**ADC Planning Consultation
Response from the Historic Buildings Adviser**

Application Number	R/73/12/L & R/72/12
Address	2 Manor Cottage, Preston Manor, Rustington
Description	Proposed front porch
Case Officer	Peter Cleveland
Site Visit	16 May 2012

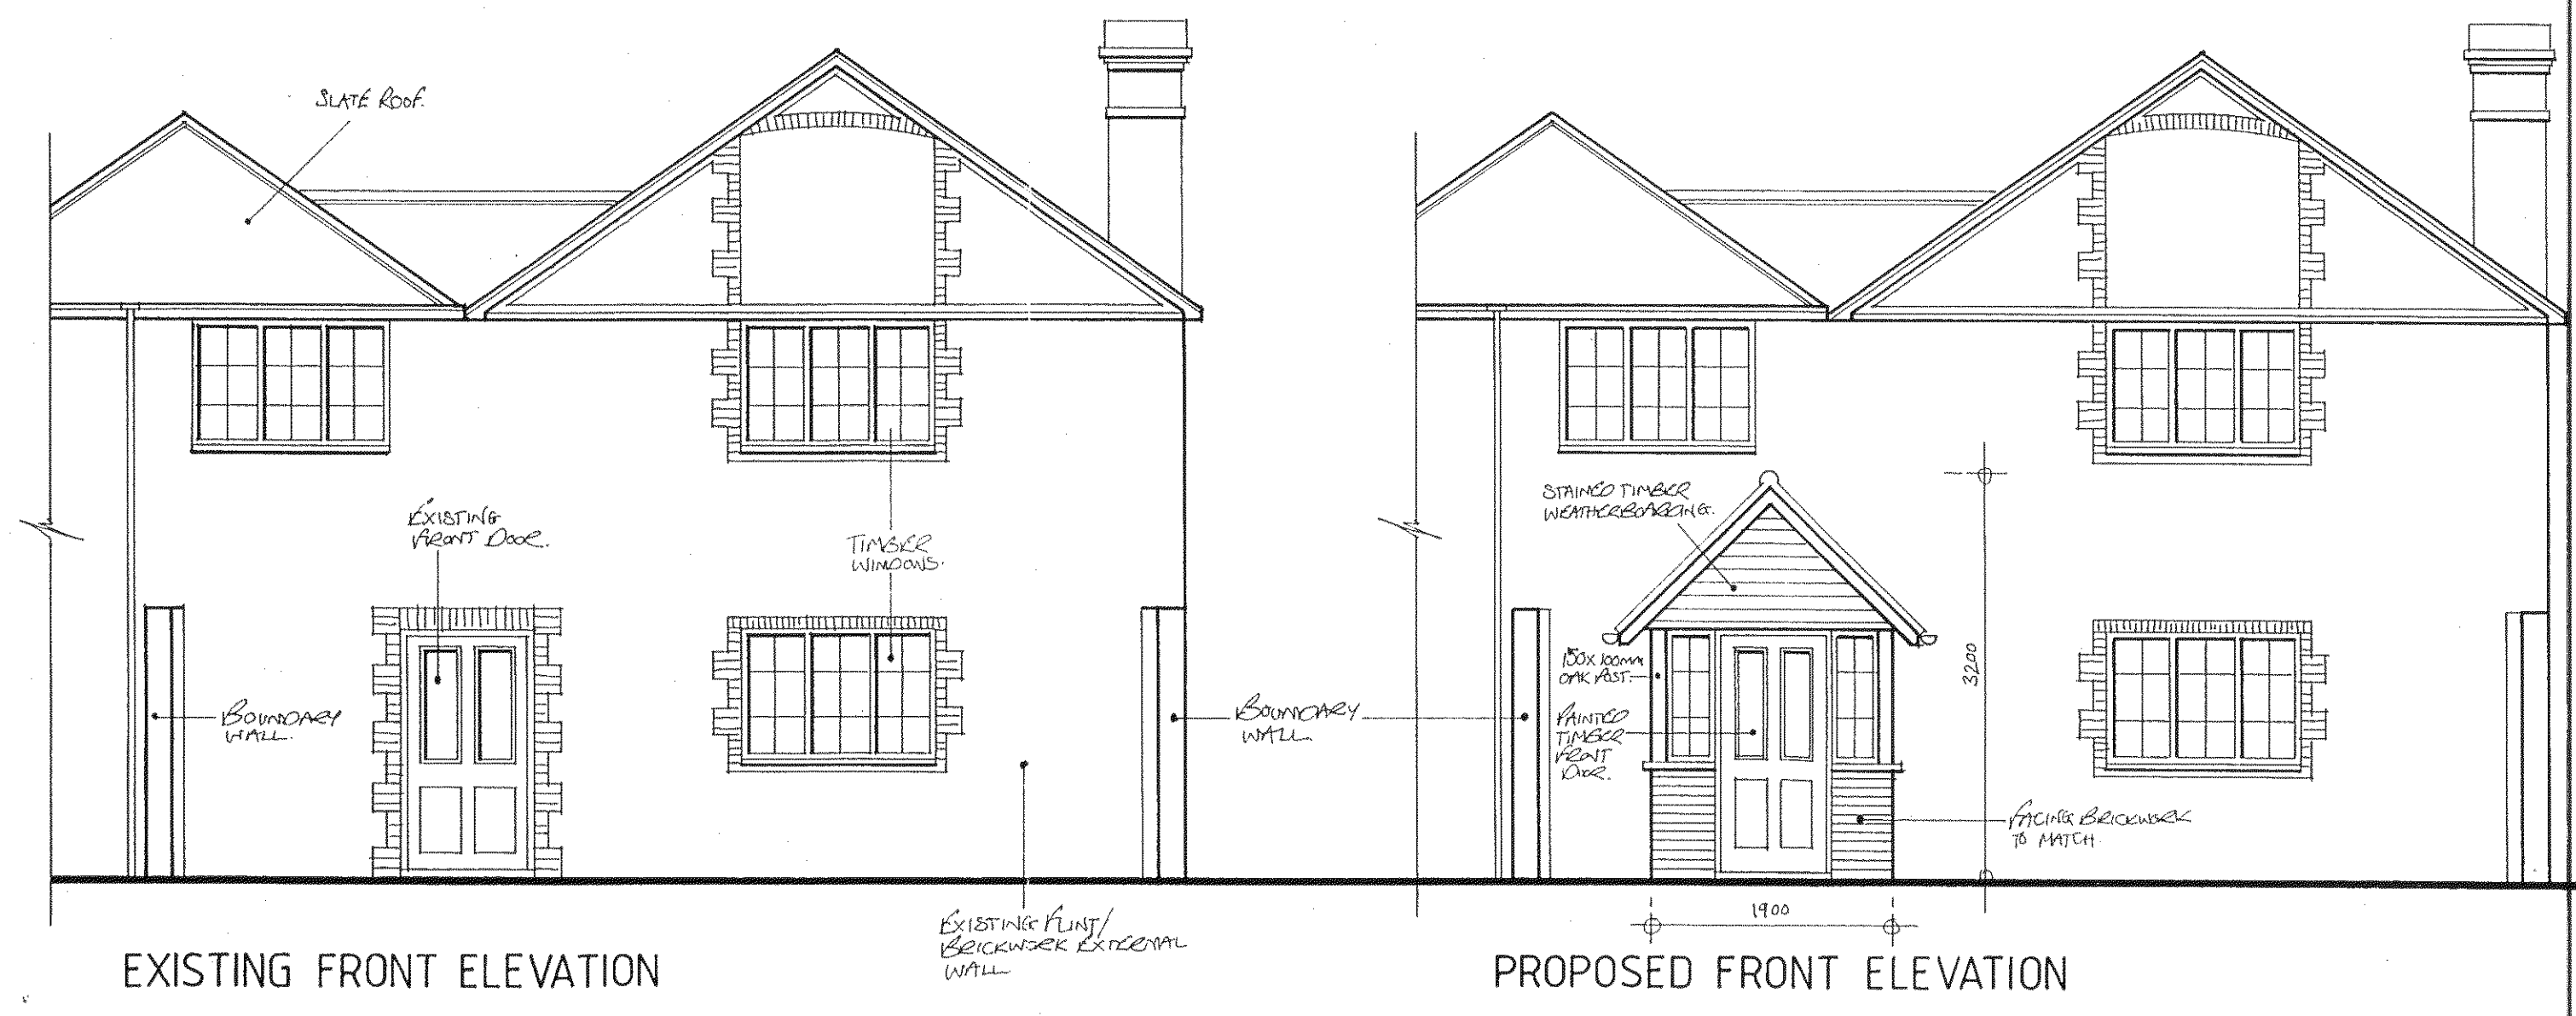
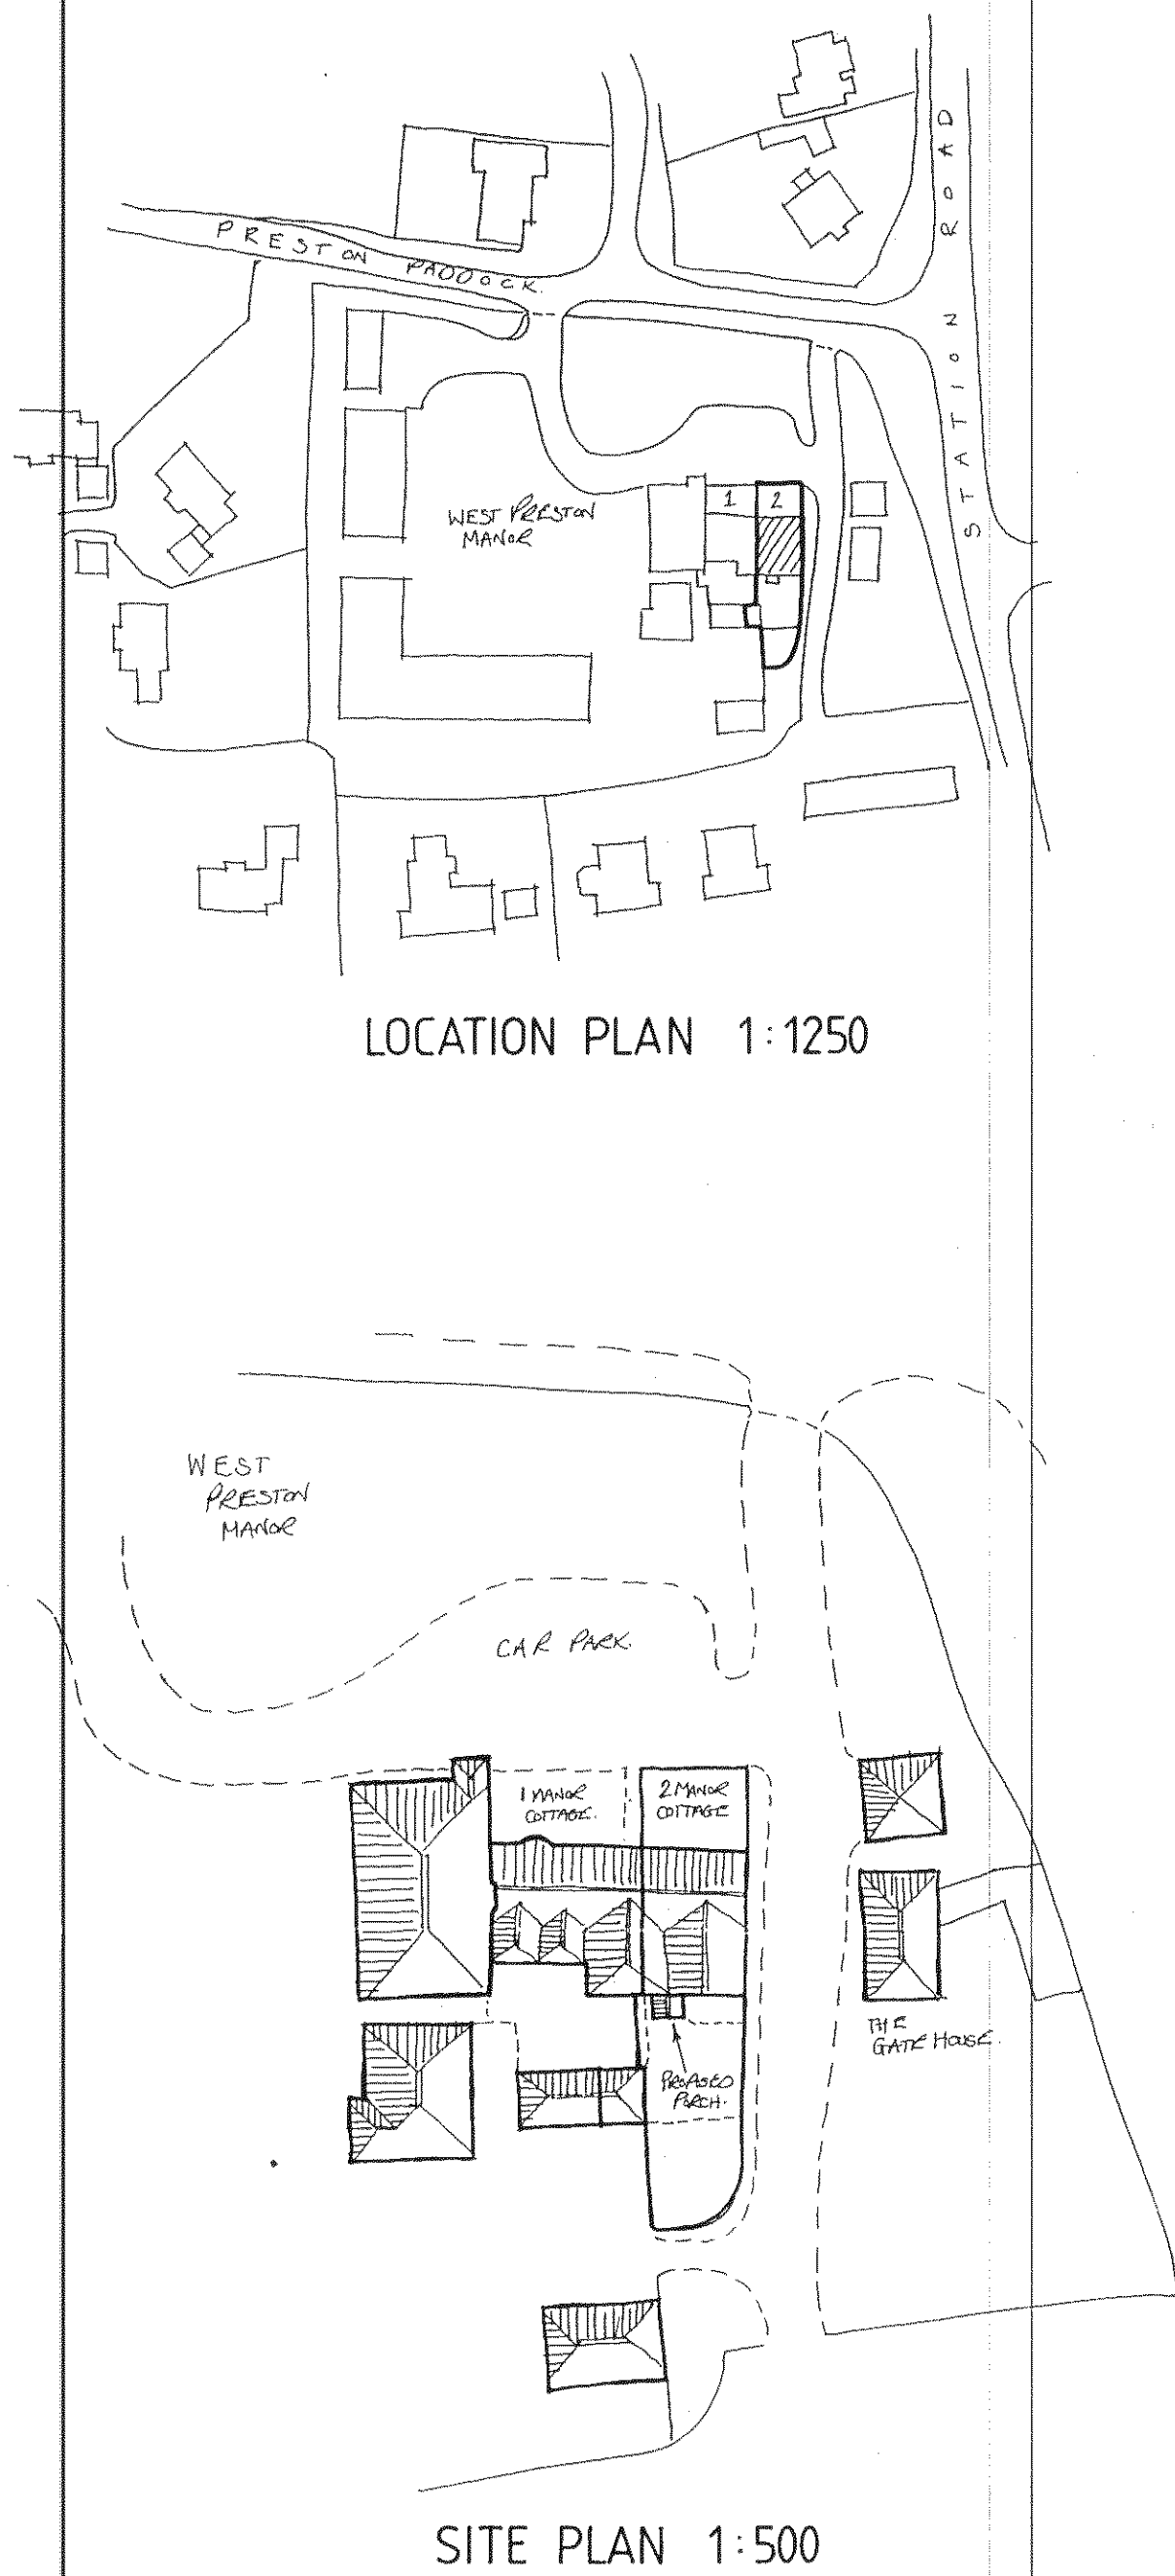
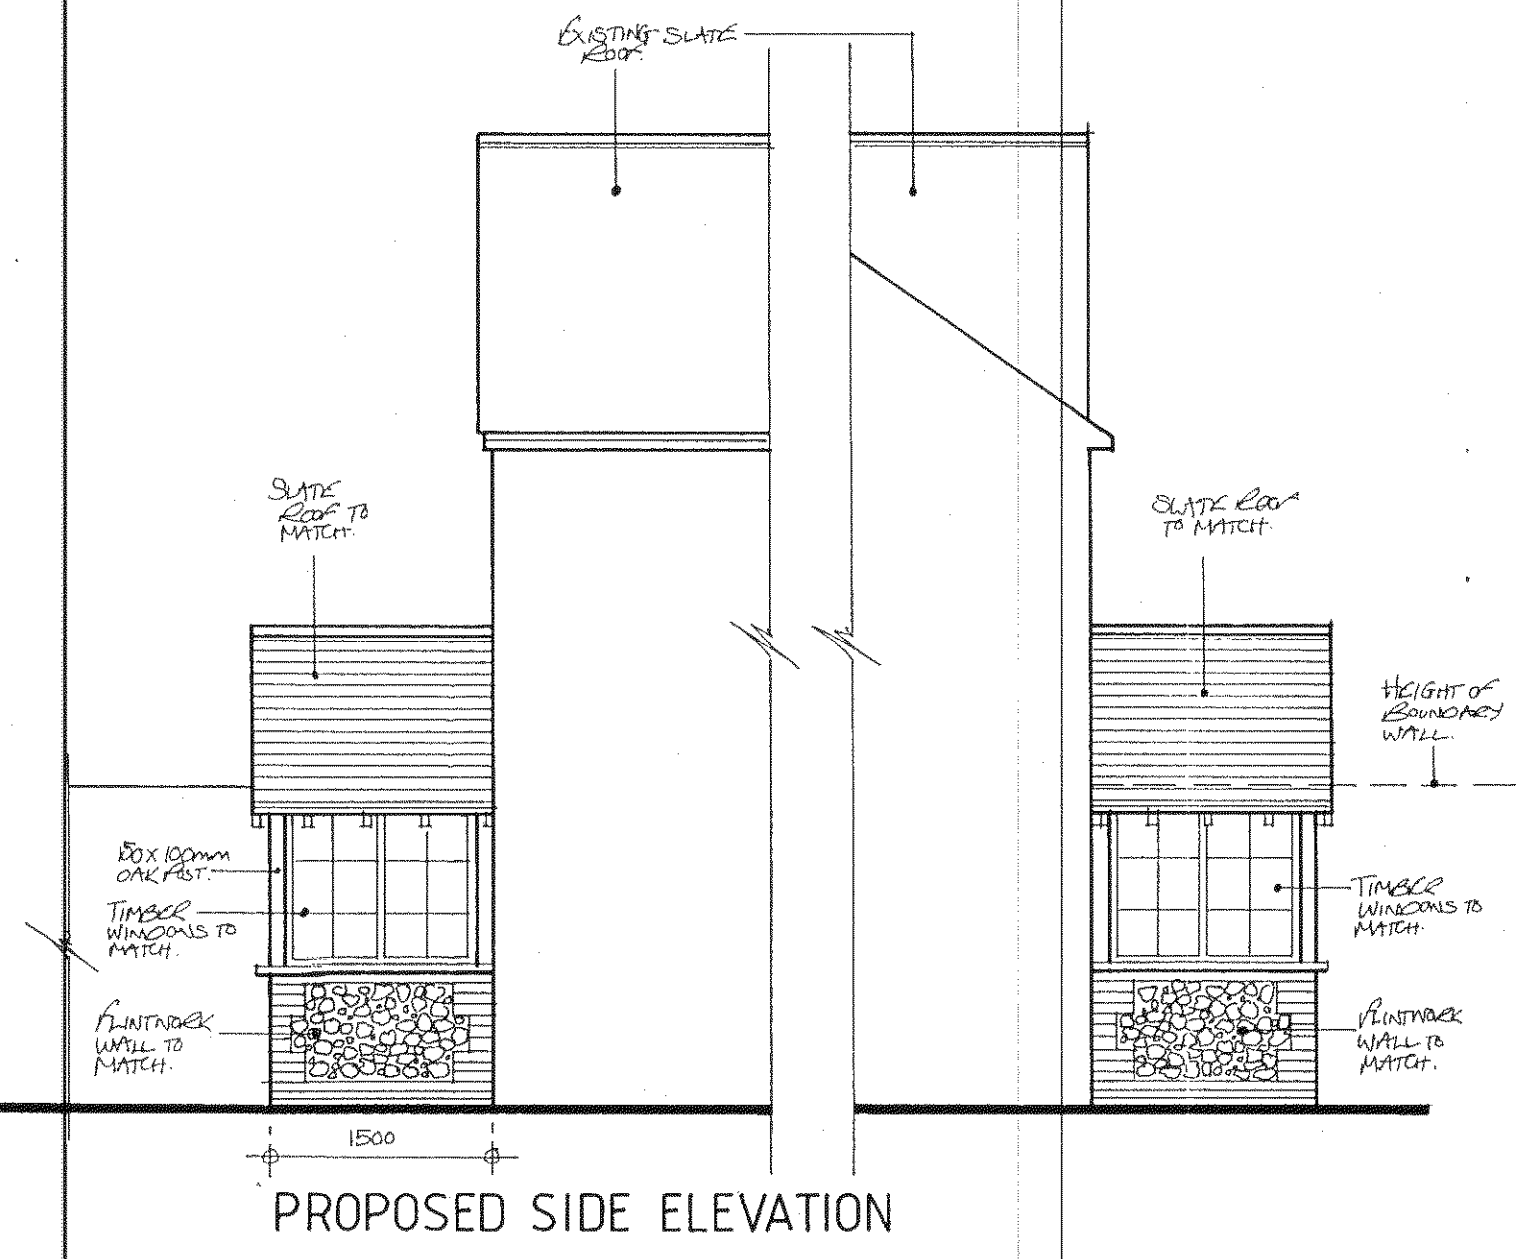
Whilst the cottages that make up the north wing are earlier than the late 19th century Manor House, the rear of these buildings are predominantly ancillary in nature. The variation in roof form suggests some incremental growth here, but not as a cohesive whole and certainly not as a 'facing' elevation. The change from flint with brick string courses to purely coursed flint supports this notion, as does the fact that the flint work (to the north eastern element) matches that of the Manor House to the rear. This seems to suggest that this part of the cottage is contemporary with the Manor house and perhaps reinforces the notion that this building had a service function.

The proposal to add a porch here therefore raises some concerns as it impacts on this character and potentially its special interest. It is certainly not sympathetic with the main building and on this basis cannot be supported.
